CLYMPING
PARISH COUNCIL34A Thorn Road
Worthing
West Sussex
BN11 3NDPeter J Bilbrough, F Inst L Ex
Clerk to the Council
Tel: (01903) 603193
Email: Clymping@hotmail.com

JZP. CM1/08 The Piggery – No objection

Clymping Parish Council accepts that Arun District Council will probably grant permission for this application by default. However they would like to raise some matters of serious concern and hope that the Planning Department will impose the following conditions.

SITE PLAN 1:500@A1

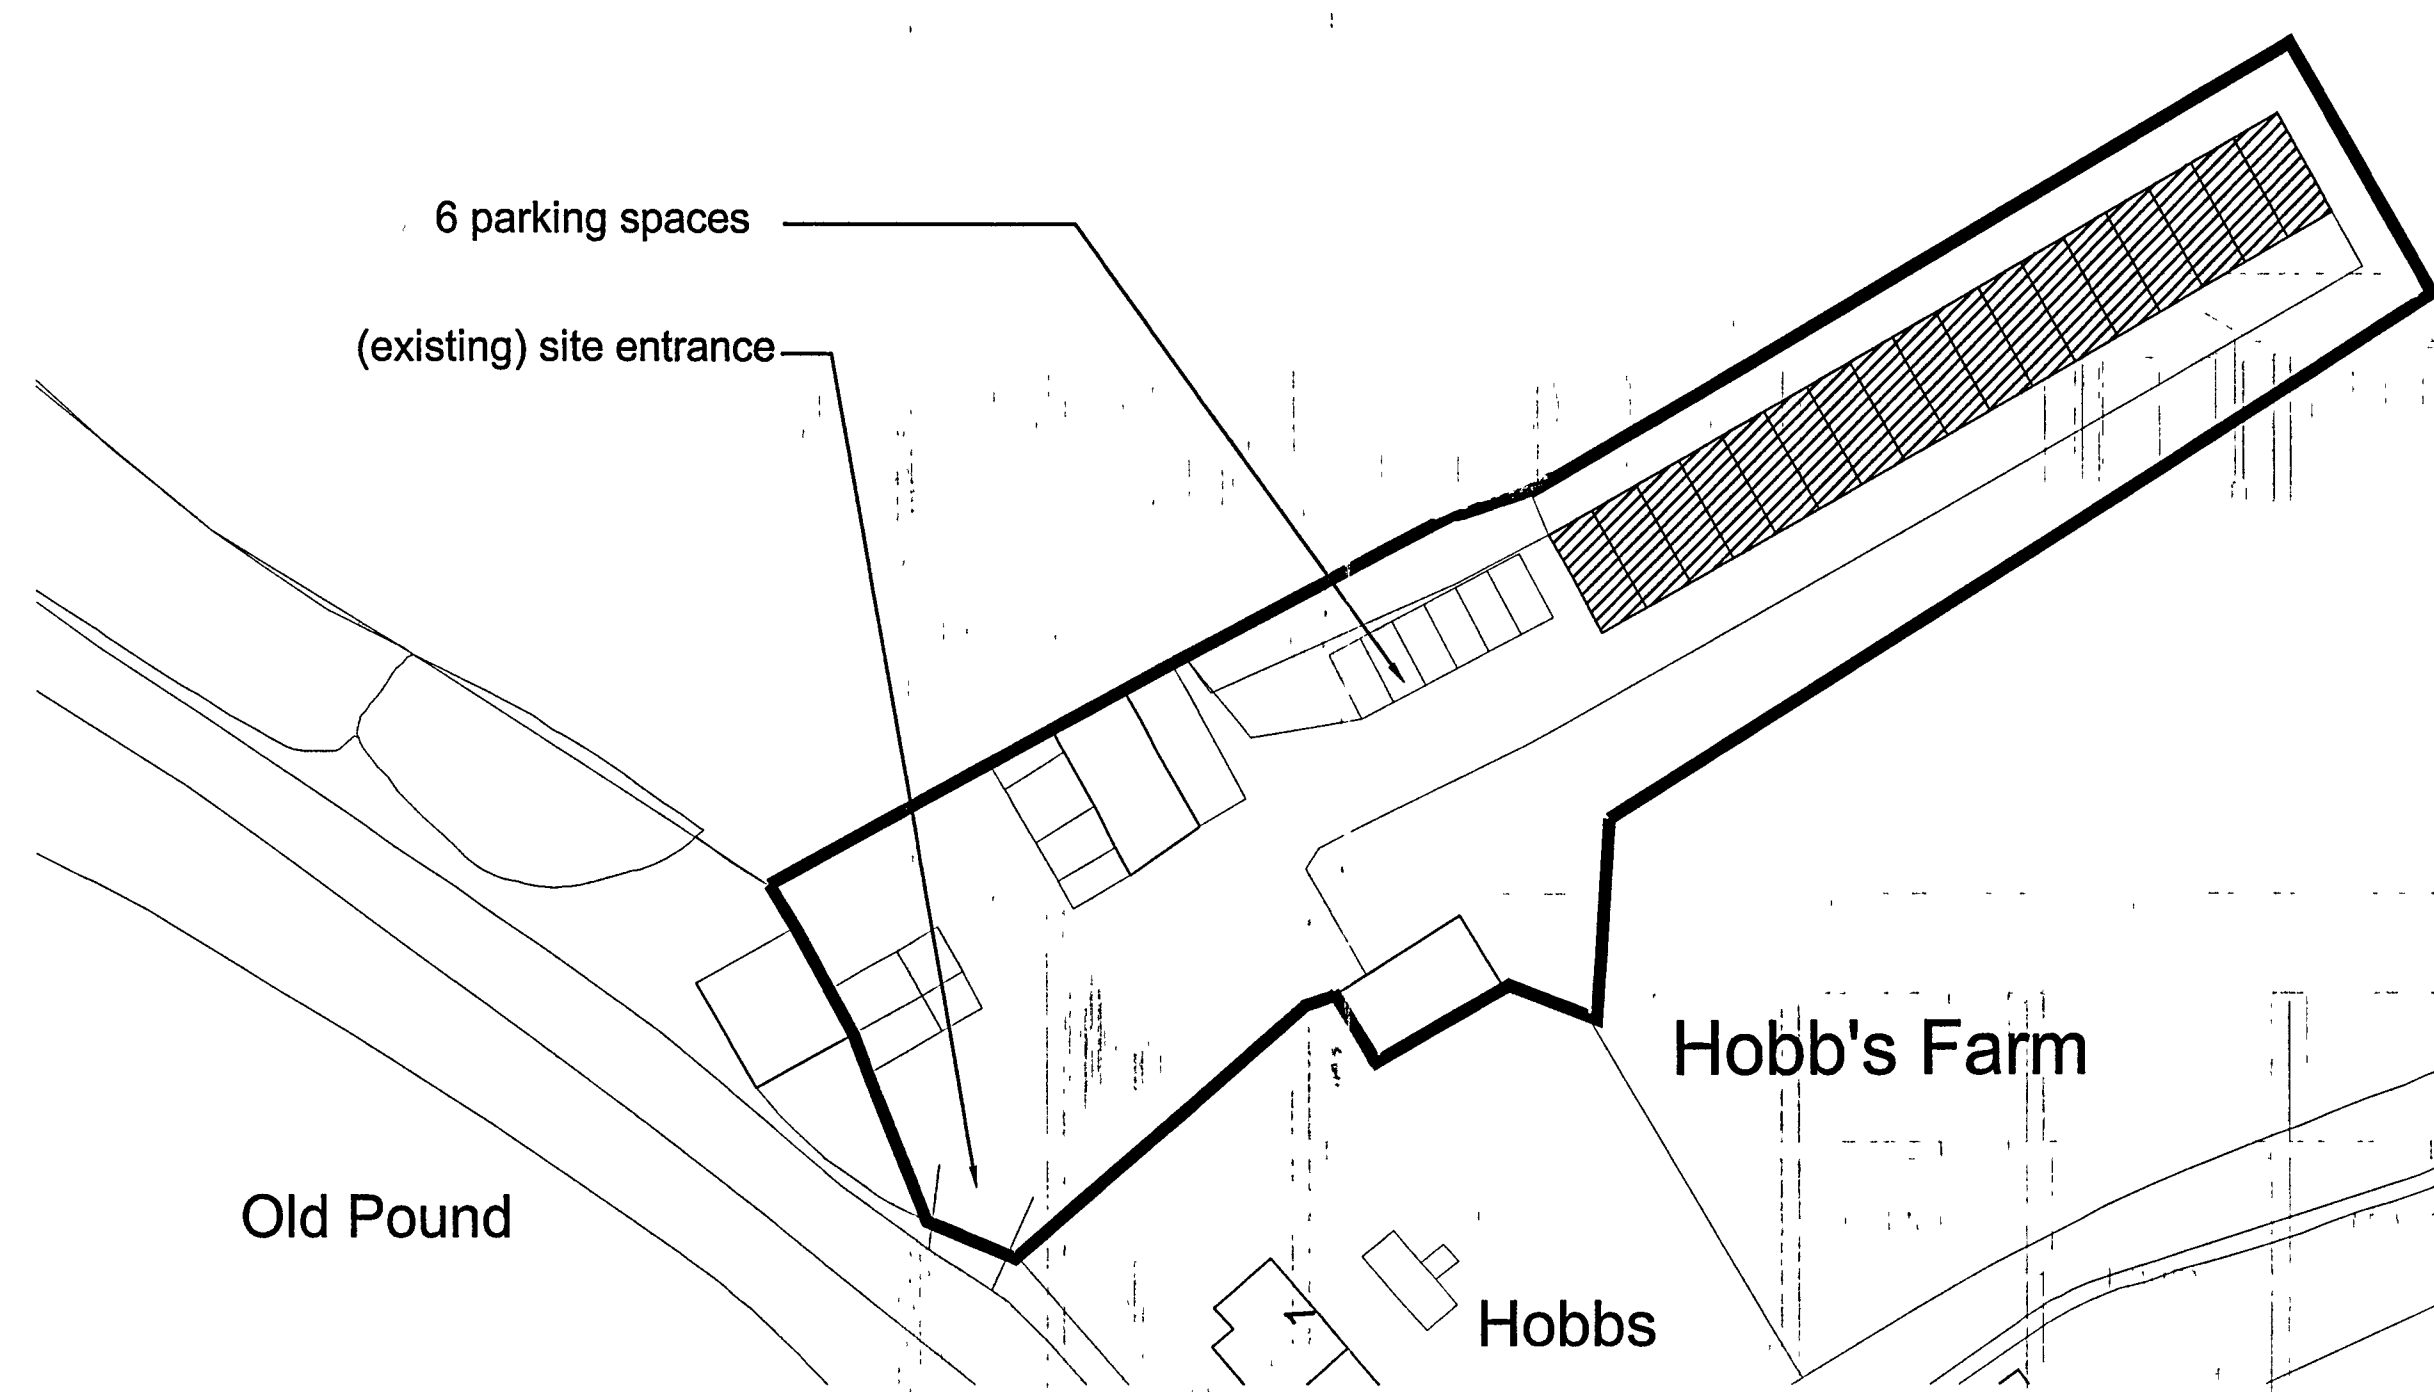
- 1.Deletion of footway. There is no recognised footpath or footway or track across the field from the farm shop to the piggery and this must never be permitted. The land must remain cultivated.

- 5.The partially demolished flint wall at the entrance should be reinstated in keeping with The Pound and other similar walls in Clymping Street.
- 6.This building must have permission for office use only in perpetuity and must never be allowed to be extended in size, or raised in height.
